Application for Plan Review

July 22, 2012

Carolina Signs and Service
Lot #2 Monor SD
Angier, NC 27501

Application Number 12-50029369

Proposed Sketch Plan for Review
Carolina Sign and Service LLC
 Town of Angier Black River Township
 Harnett County, NC Zoned: CP
 Scale: 1" = 30' Date: 2-7-12
 NC PIN: 0673-02-0394 PARCEL ID: 040673 0110 02

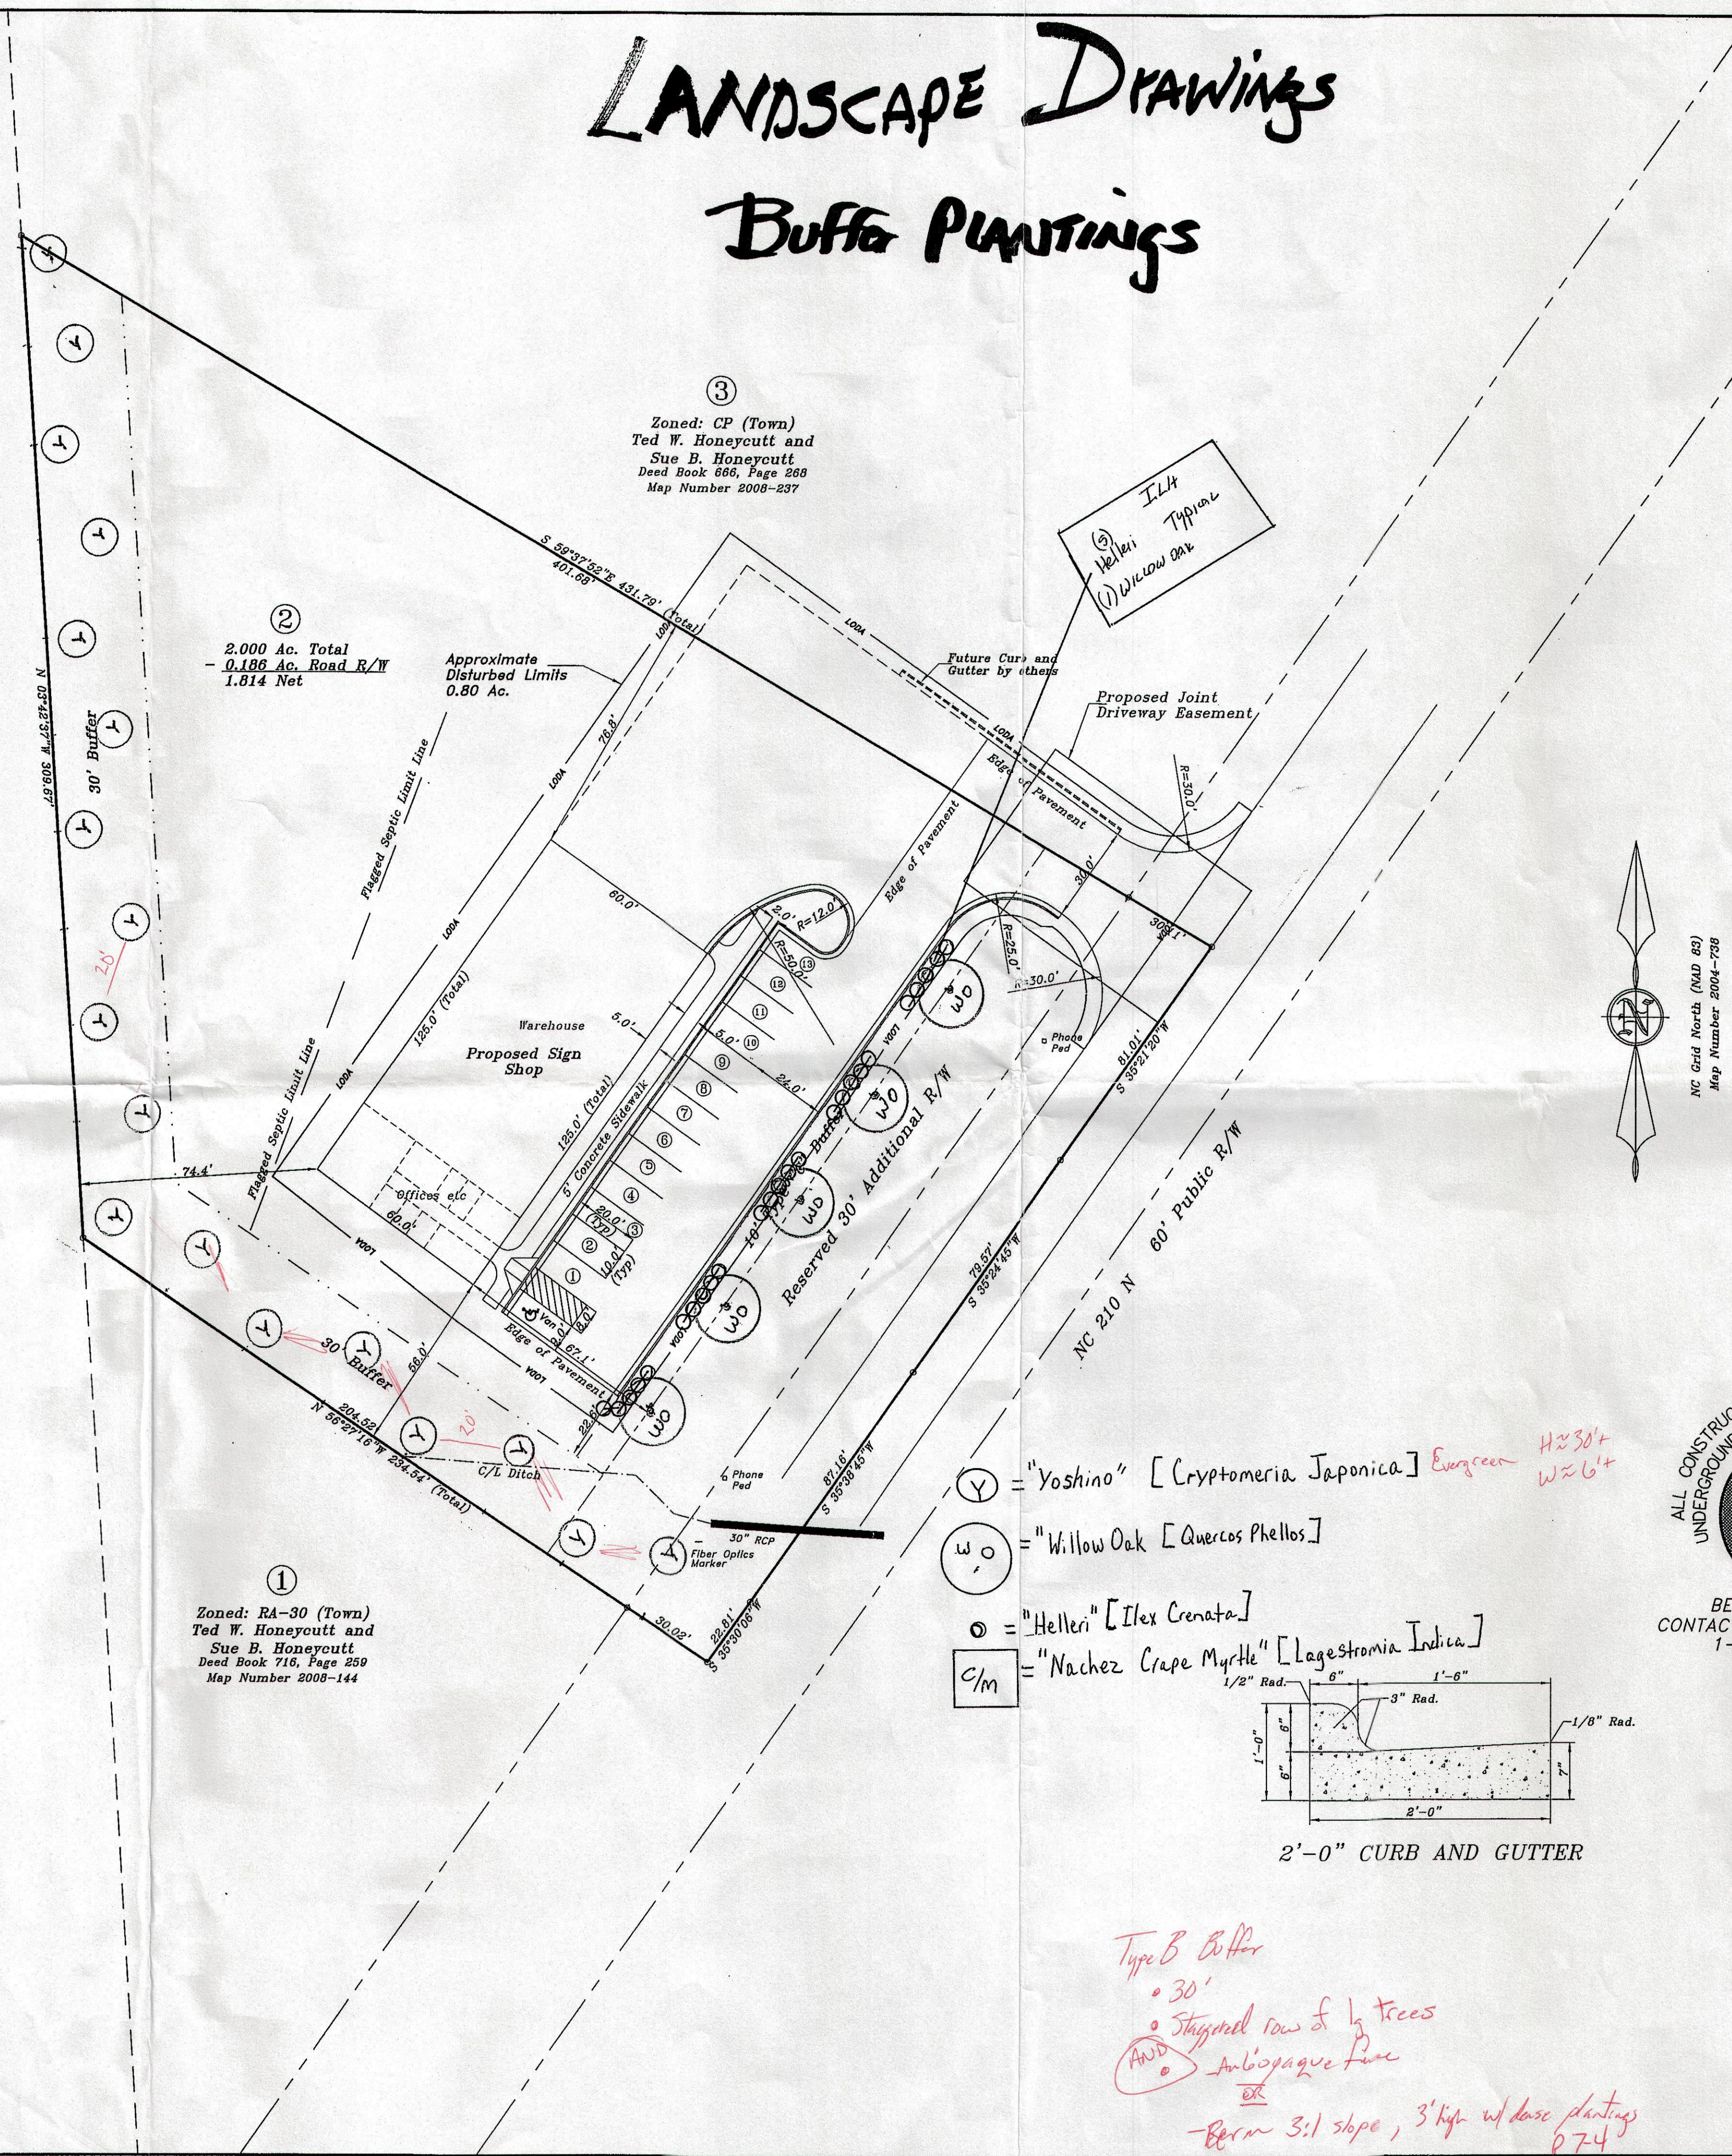
- **505.1 Physical Address**

- The physical address of the building shall be posted in a conspicuous place so that it can be seen on approach from the road, access road, and/or parking lot.
-

- The numbers used to make up the physical address shall be at least 5 inches in height.
- Also, place 5 inch address numbers on the rear doors of a multi-tenant building.
